2023/0311

Erection of two storey and single storey extensions to rear of dwelling.

102 Upper Hoyland Road, Hoyland, Barnsley, S74 9NL

TITLE G. F. Layout as Proposed

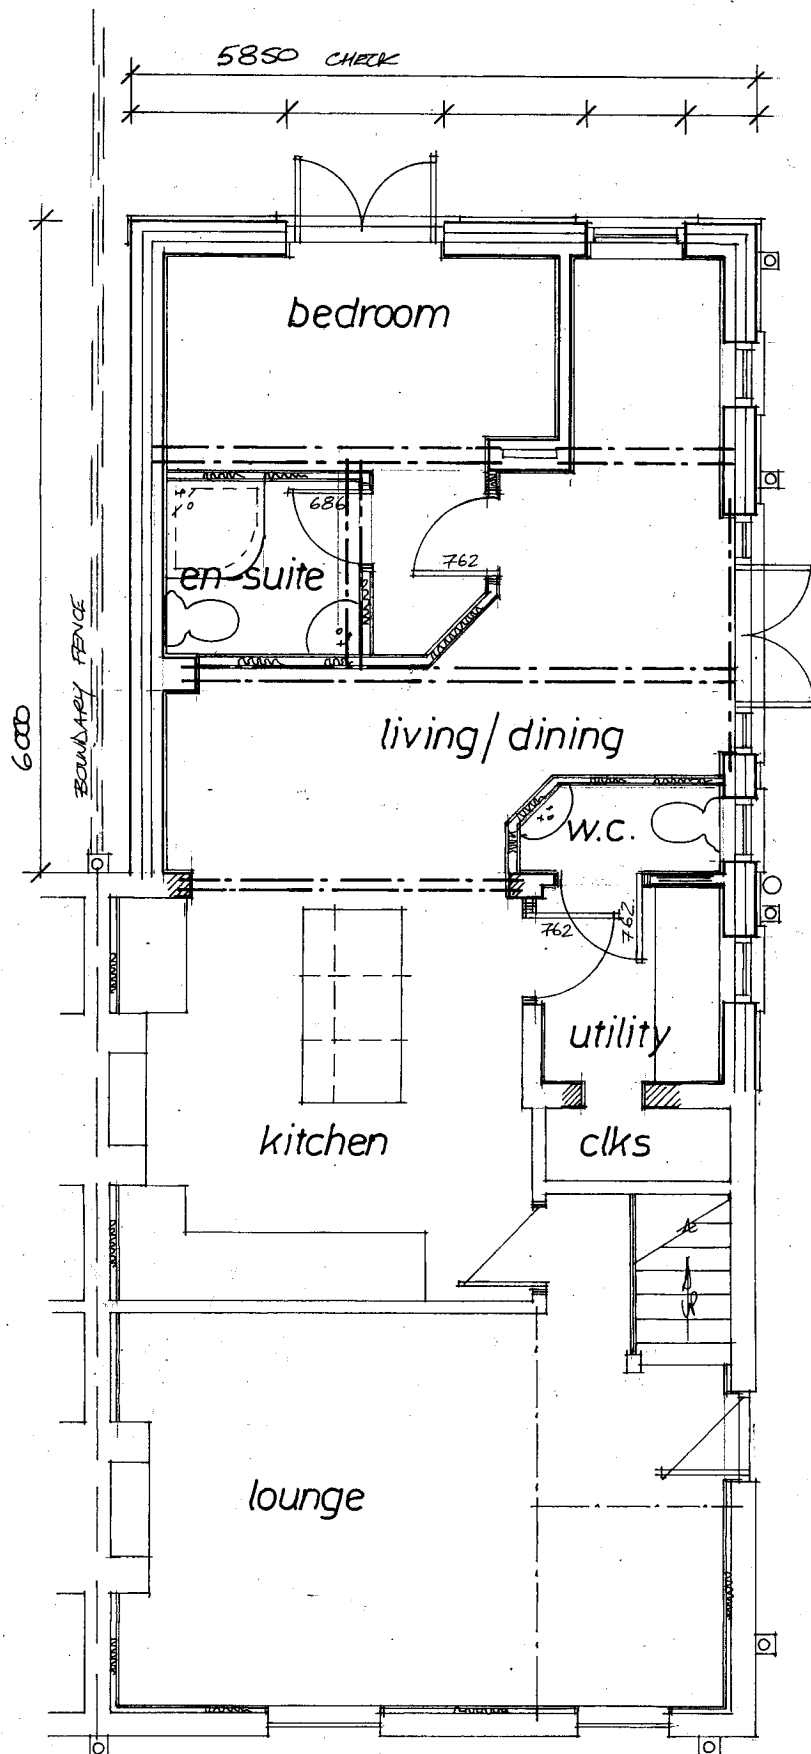
The applicant seeks permission for the erection of a single-storey and two-storey rear extensions. The single storey rear extension is to project 6m from the rear elevation, extending the full width of the property. The two-storey rear extension is to project between 2 and 4m from the rear elevation, the shorter projection being located adjacent to the party boundary.

Whilst the single storey element would fall within the 45-degree quadrant, it does fall within the parameters of the larger home extension when taken from the adjoining dwelling and given that there have been no objections received from the neighbouring dwelling it is considered acceptable in this instance. The two-storey element has been designed with a step in to avoid intersecting the quadrant, which will limit reducing levels of outlook.

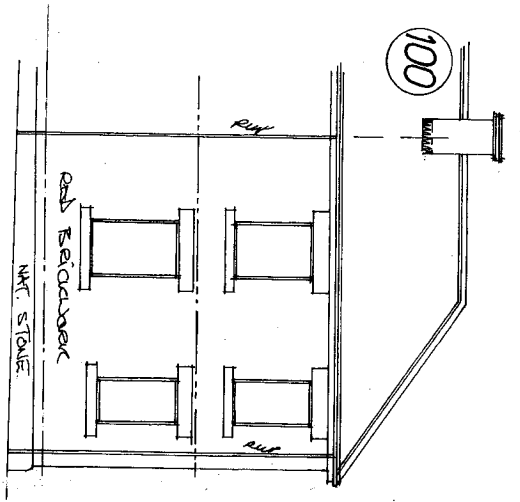
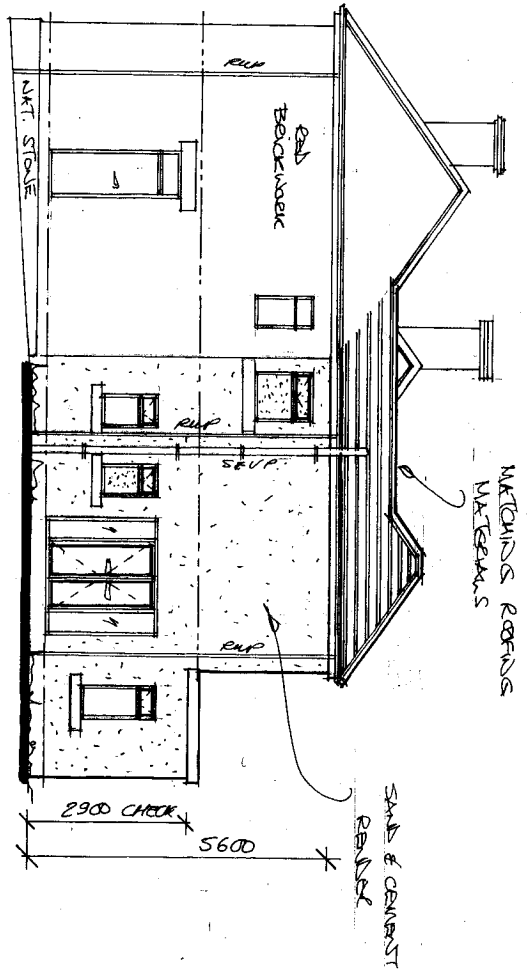
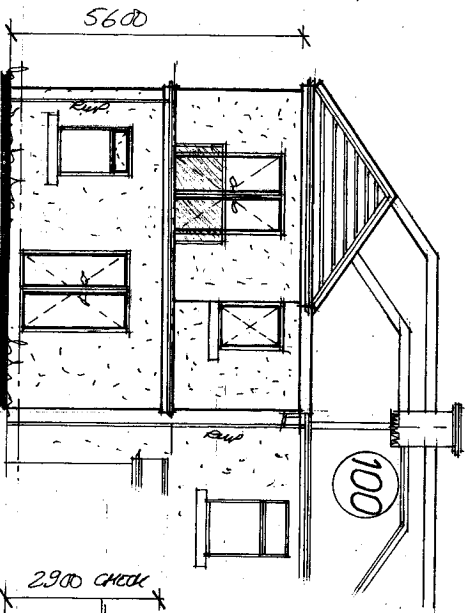
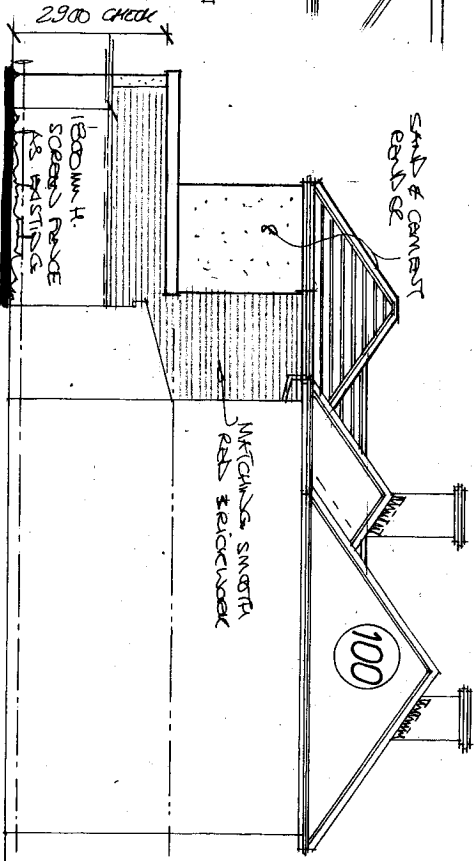
The design of the existing dwelling and its flat roof projection, and construction materials limit the design of the proposed extension. The scheme was initially submitted with flat roofs to all elements; however, this was considered unacceptable given the prominence of the north-western side elevation within the street scene.

Amendments were sought and submitted which includes a hipped roof on the two-storey element adjacent to the north-western boundary. Whilst not ideal due to the varying ridge heights it is considered an improvement of a flat roof and avoids the awkward junction of a flat roof with hipped roof. It is acknowledged that the smaller two-storey rear element and the single storey element are designed with a flat roof, however, these elements are not as prominent within the street scene and are screened by other elements the proposal and the existing detached garage located along the north-western boundary.

The existing two storey flat roof projection and the rear elevation have been covered in a pebble dash render; it is proposed to have the proposed extensions also constructed in this render which, whilst not ideal given the prominence of the side elevation, does match the existing dwelling and any other material would be at further odds.
